LU/233/14/NMA

From: [REDACTED]
Sent: 22 August 2014 13:23
To: Charlotte Burrows
Subject: Re: Decking changes
Attachments: NEW Drawing_36, Clun Road, Littlehampton Layout1 (1).pdf

DRAWING NO:	REVISION:
1043/1	A

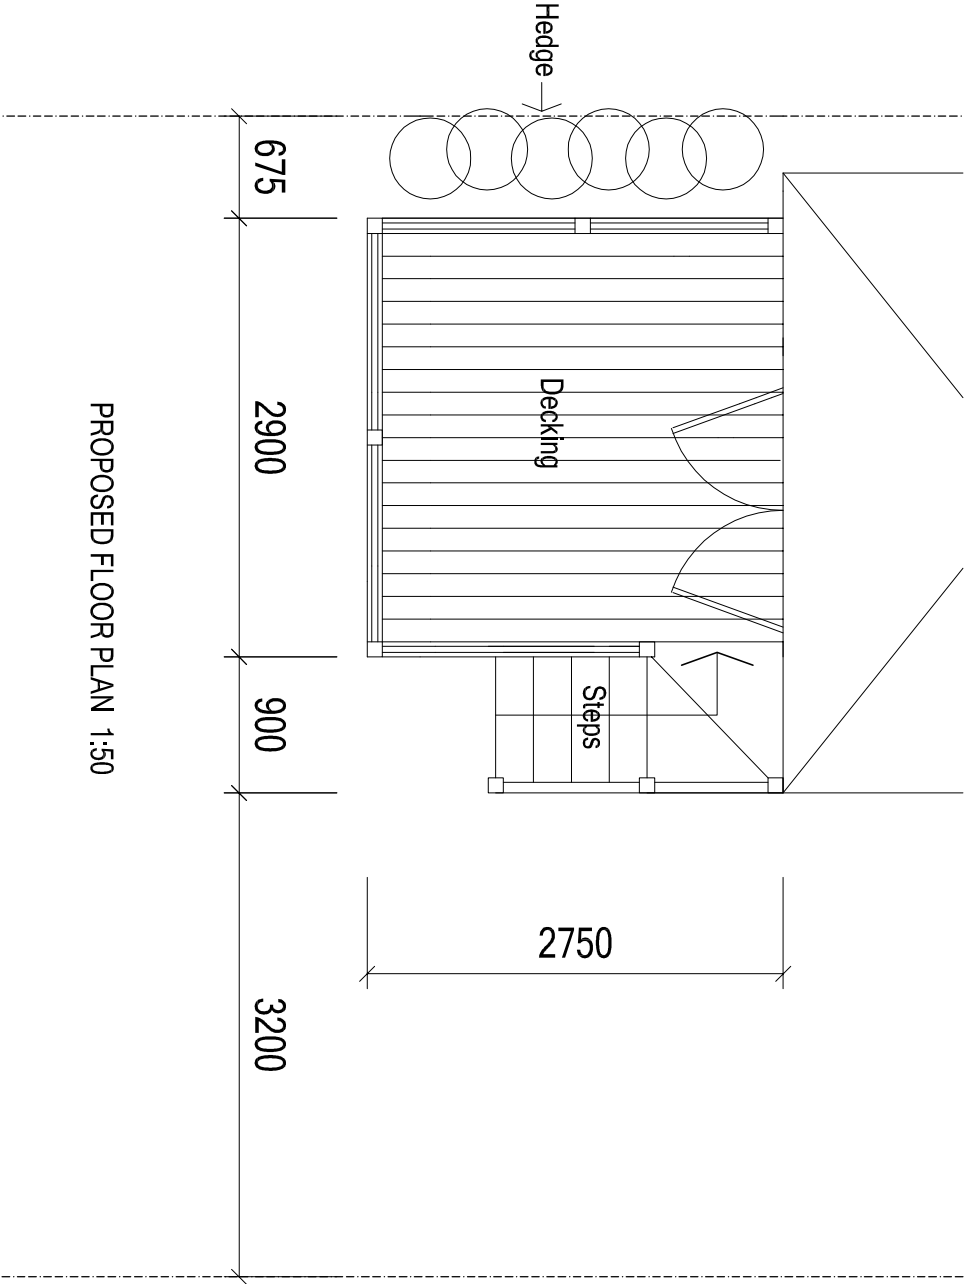
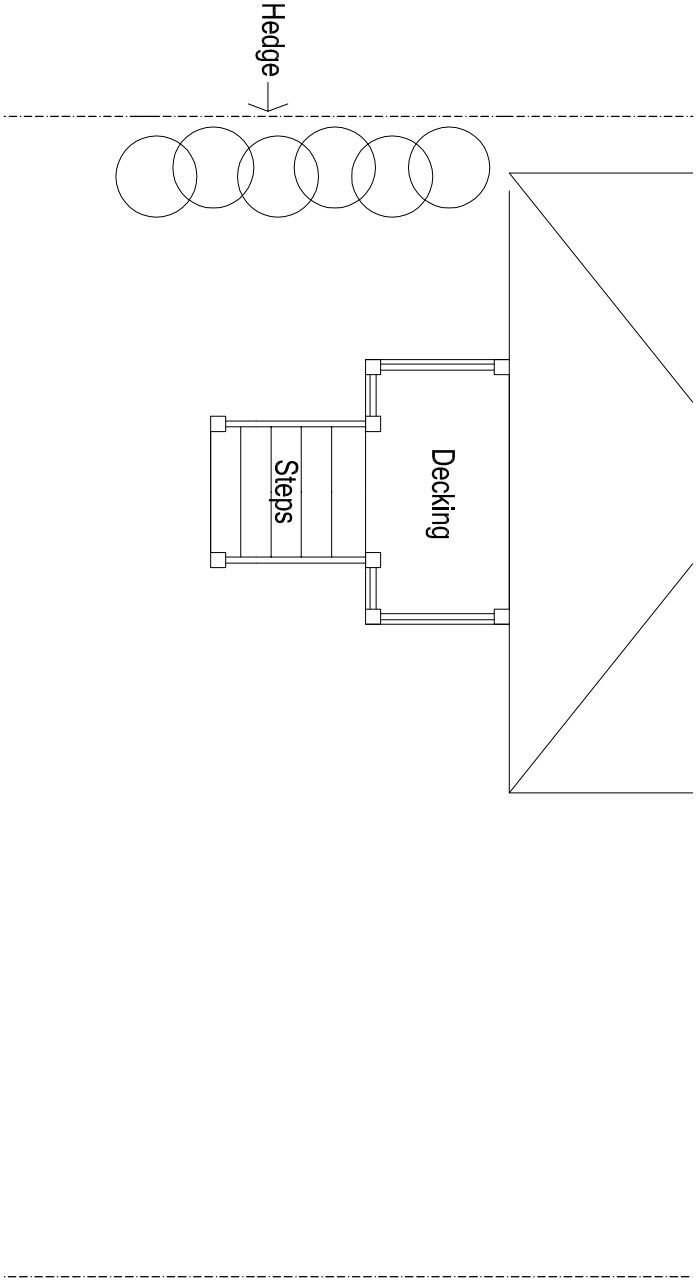
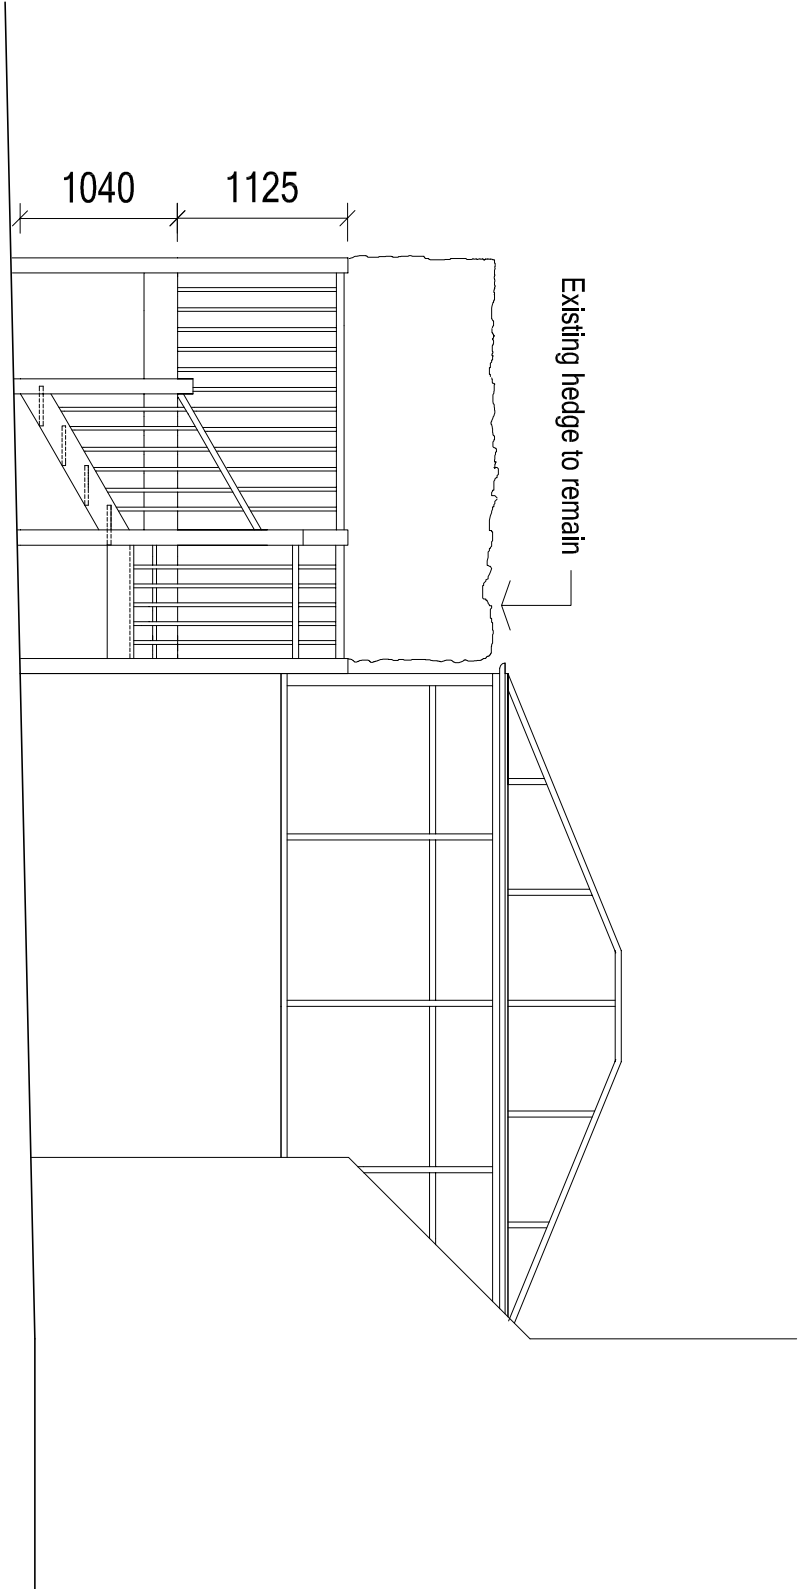
Unfortunately the drawings submitted are still omitting to show the hedge, I have discussed this with the Team Leader for the area and we will require the hedge to be clearly indicated on the proposed plans.

Hi Charlotte.
Please find drawing that had the hedge missing is this OK.
have you got a direct number
Regards
Mick
